**WA/23/26/L**

**Address:** The Old Vicarage The Street Walberton BN18 0PQ

**Proposal:** Listed building consent for construction of oak framed car port and associated works.

Garage Floor Plan, Roof Plan, Section
and Elevations

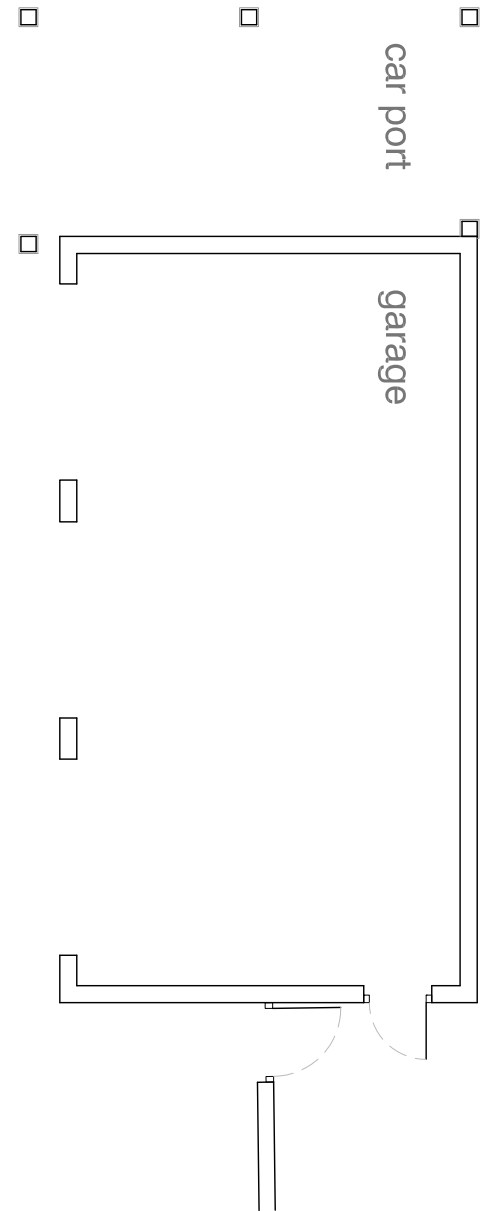
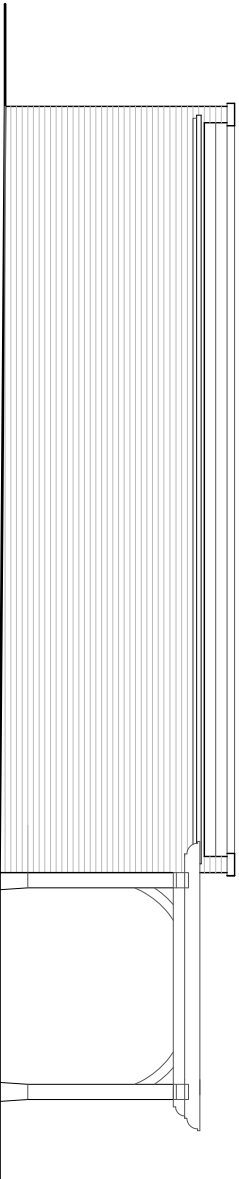
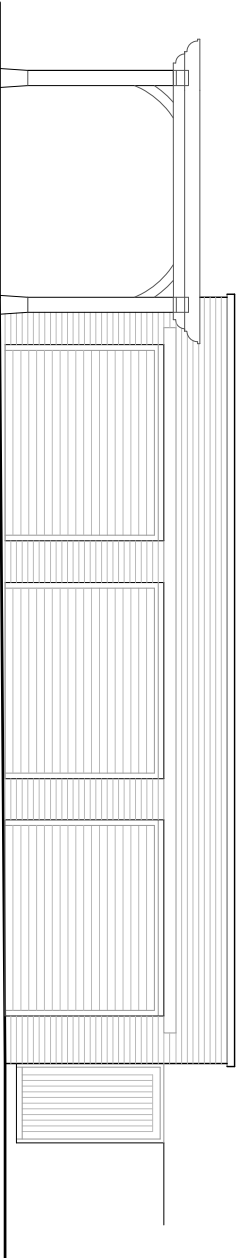
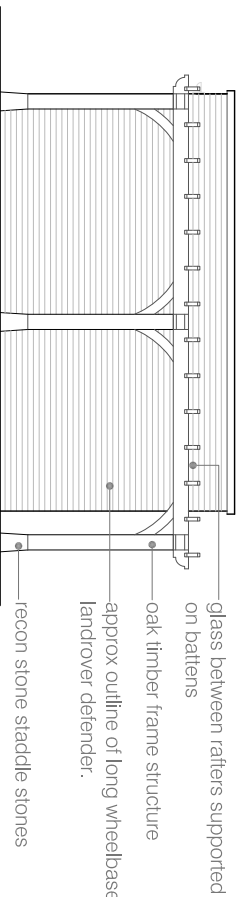
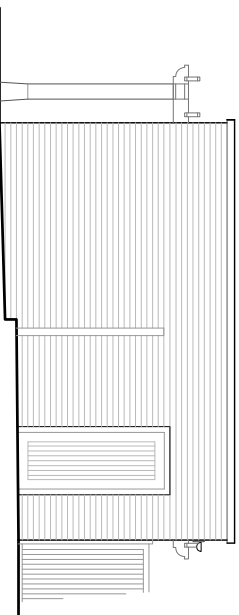
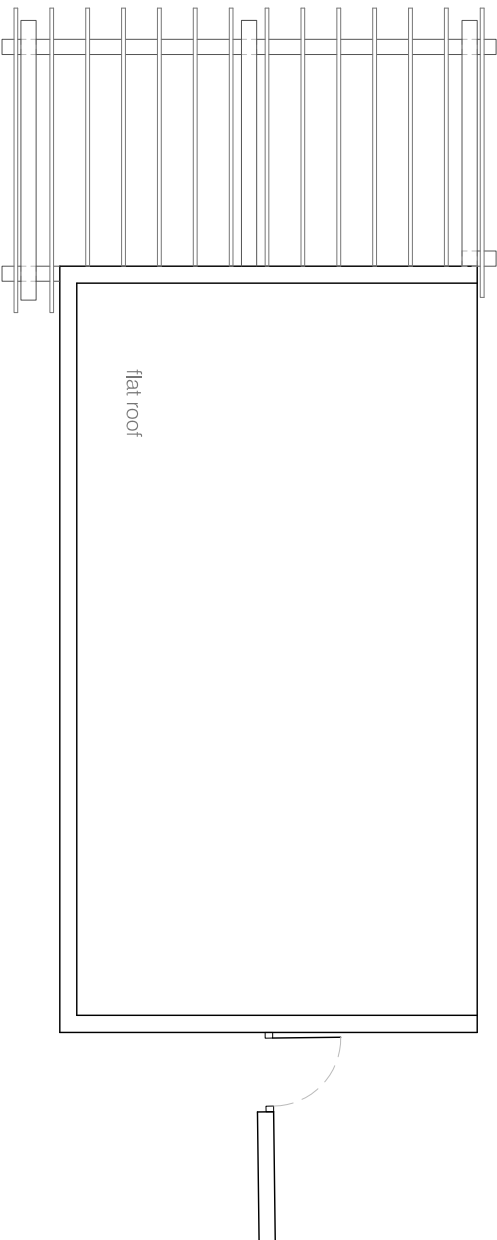
The proposal is for a car port which would be attached to an existing garage structure which is located in the grounds, to the front of the listed building. The existing garage building is large and does not make a positive contribution to the setting and views towards the listed building. There is clear scope for enhancement.

Whilst the proposal would extend this structure it could also help to improve its appearance. It is assumed that a car is already parked in the area that is proposed for the car part so this structure would help to also screen that, which is somewhat positive.

The only location from which the proposed car port would be visible from is from the road to the north of the site. This is through the small opening where the existing double gates provide pedestrian access to the property from The Street.

I note from the heritage statement that the intention is to provide additional planting along the northern boundary flint wall to the east of the access gates. Further planting will also be introduced around the oak frame itself. This it is stated, will provide additional screening of this area, and the structure from the road. Whilst this concept would help to ensure that the structure is less visible and soften its impact upon views of the principal elevation of the listed house, further clarification is required.

It is not clear what the extent of the planting would be, nor what type of planting is proposed. This should be clarified. It is assumed that this would be agreed with the Council's Landscape Officer. Such details can be agreed by way of condition, subject to confirmation that the planting would provide effective screening. I would also want to ensure that the planting is retained for the long term, and if it is removed, it would be replaced.
